From: Martyn White
Sent: 14 May 2019 15:15
To: Planning.Responses
Cc: Michael Eastham
Subject: FW: BE/135/18 consultation Comments

BE/135/18

The application relates to a number of employment related buildings in an area of land identified within the Local Plan for such uses.

A: With Acoustic Barrier Daytime L_{Aeq}

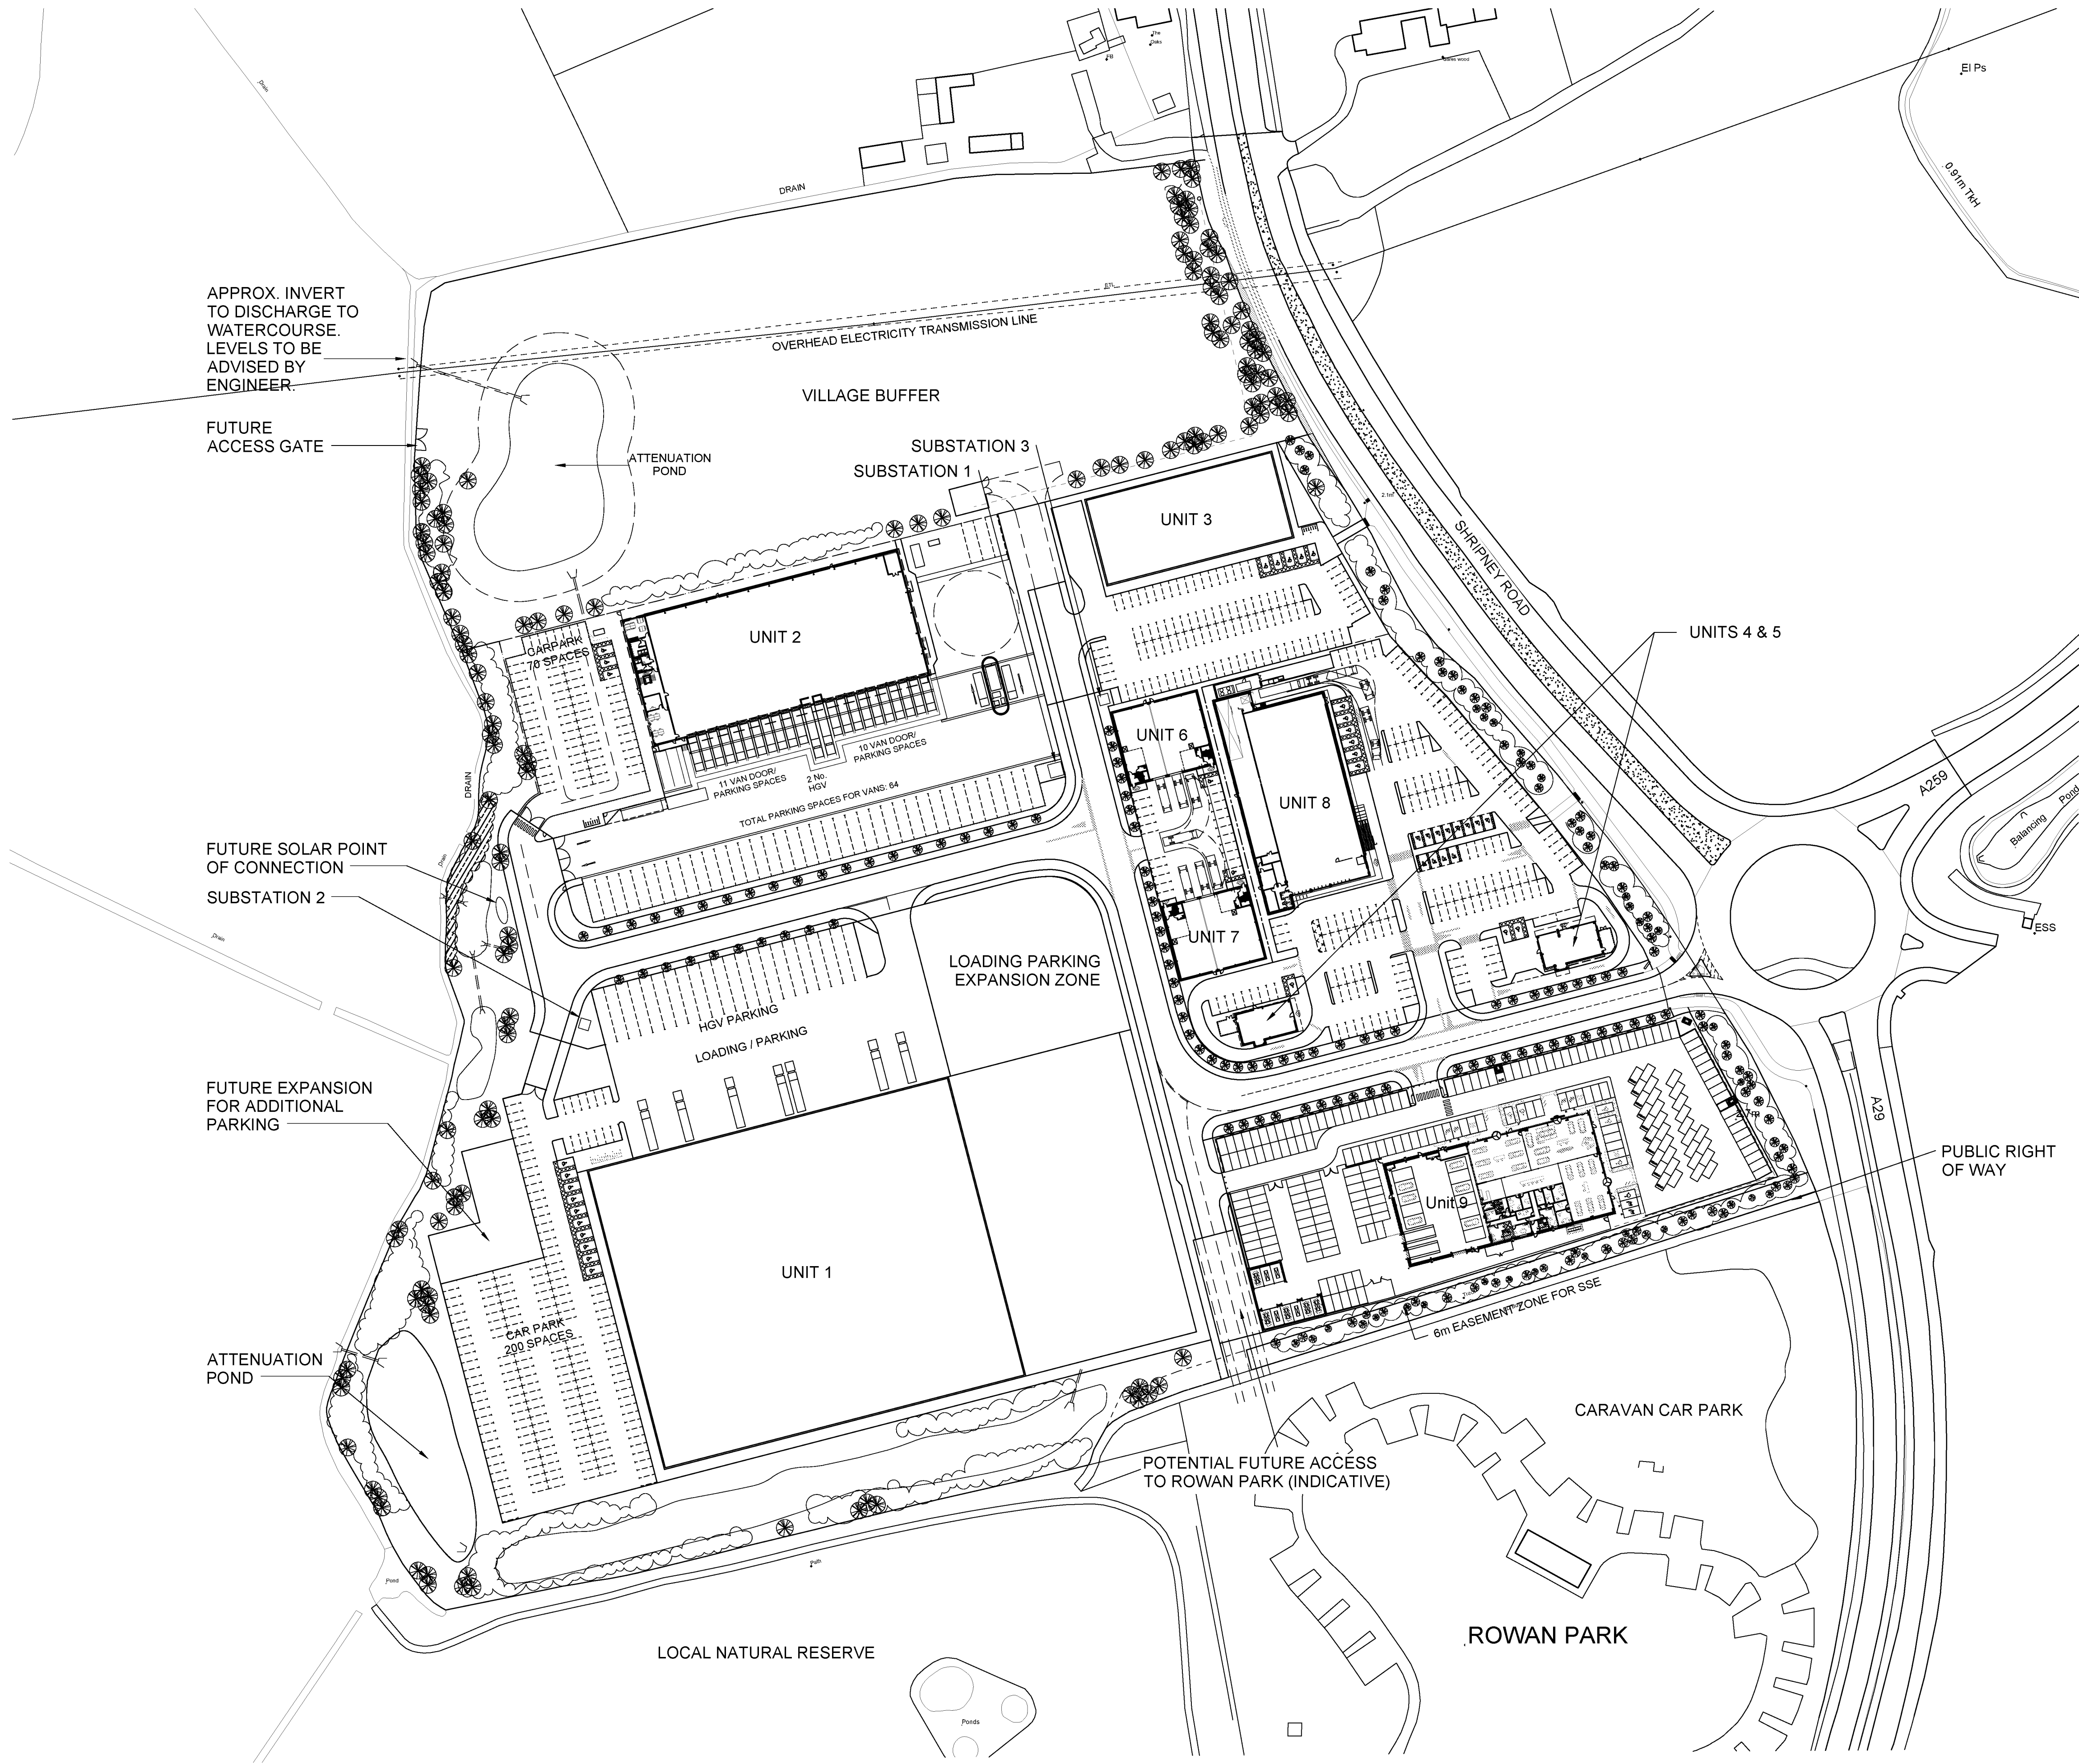
It is recommended that a detailed landscaping scheme which provides for native trees/vegetation should be prepared for the buffer zone in order to ensure that it reflects the local area. Details of how the timber acoustic fence (near unit 2) is to be treated should also be provided to the council.
